CHURCH'S CHICKEN #695
ALBUQUERQUE, NM

GRADING & DRAINAGE PLAN

C5.1

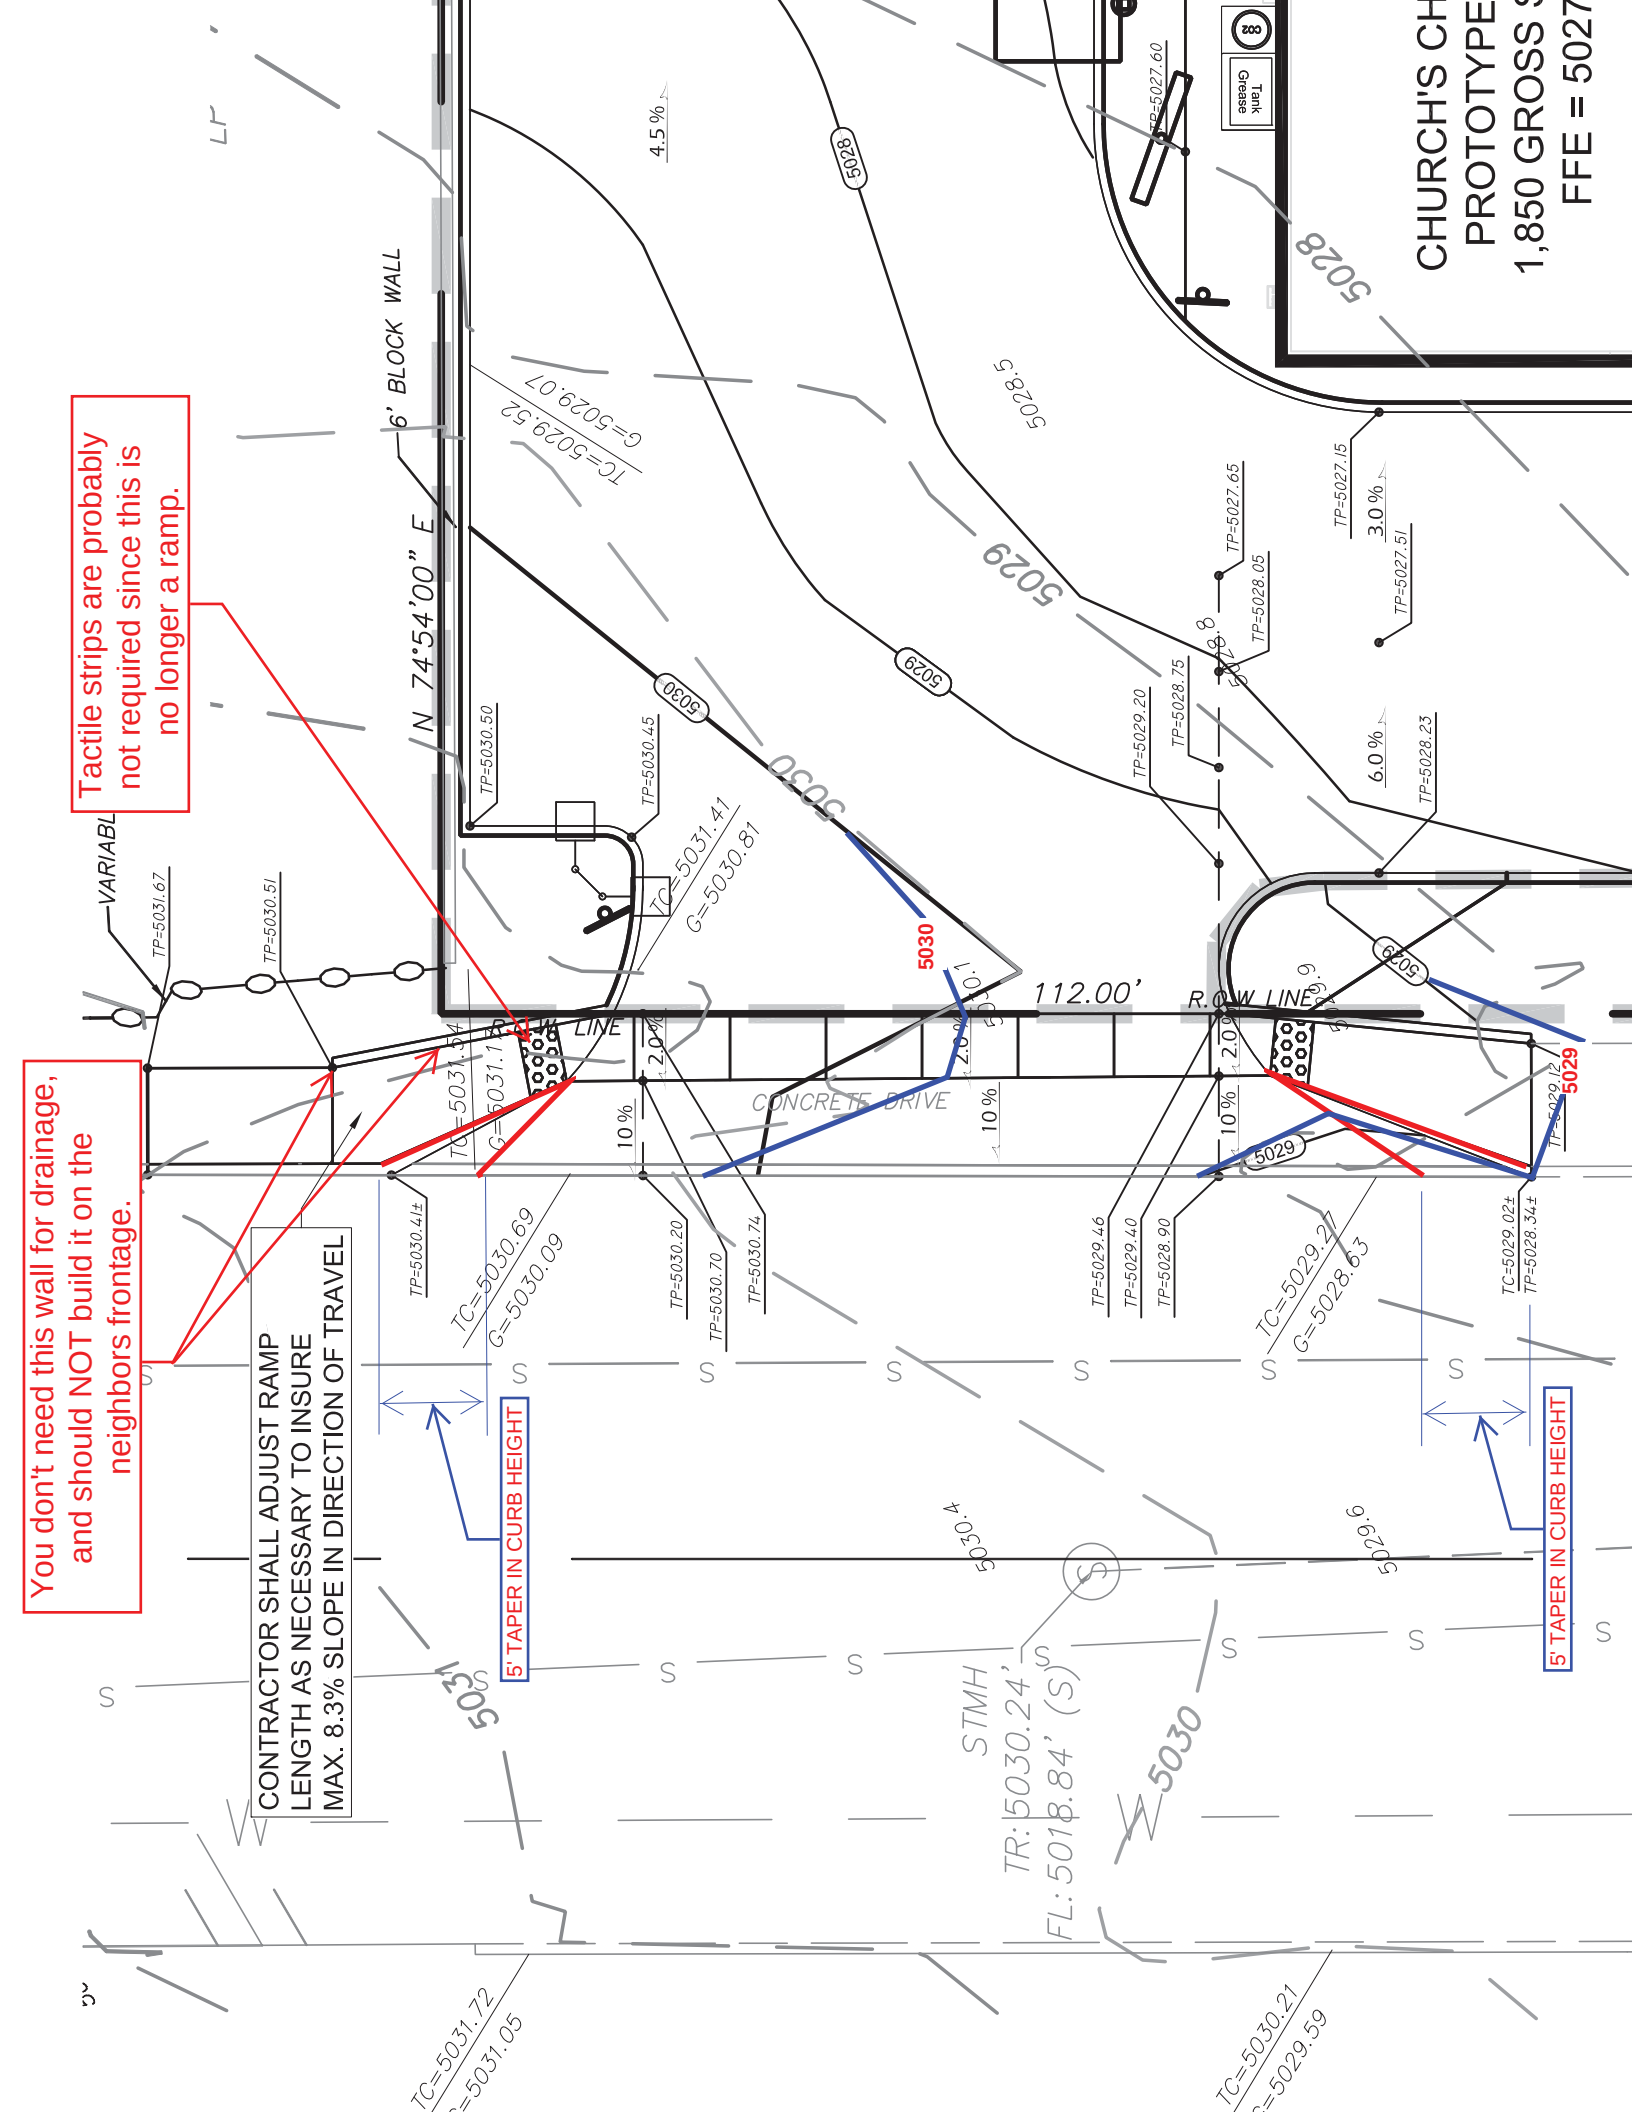
You don't need this wall for drainage, and should NOT build it on the neighbors frontage.

Tactile strips are probably not required since this is no longer a ramp.
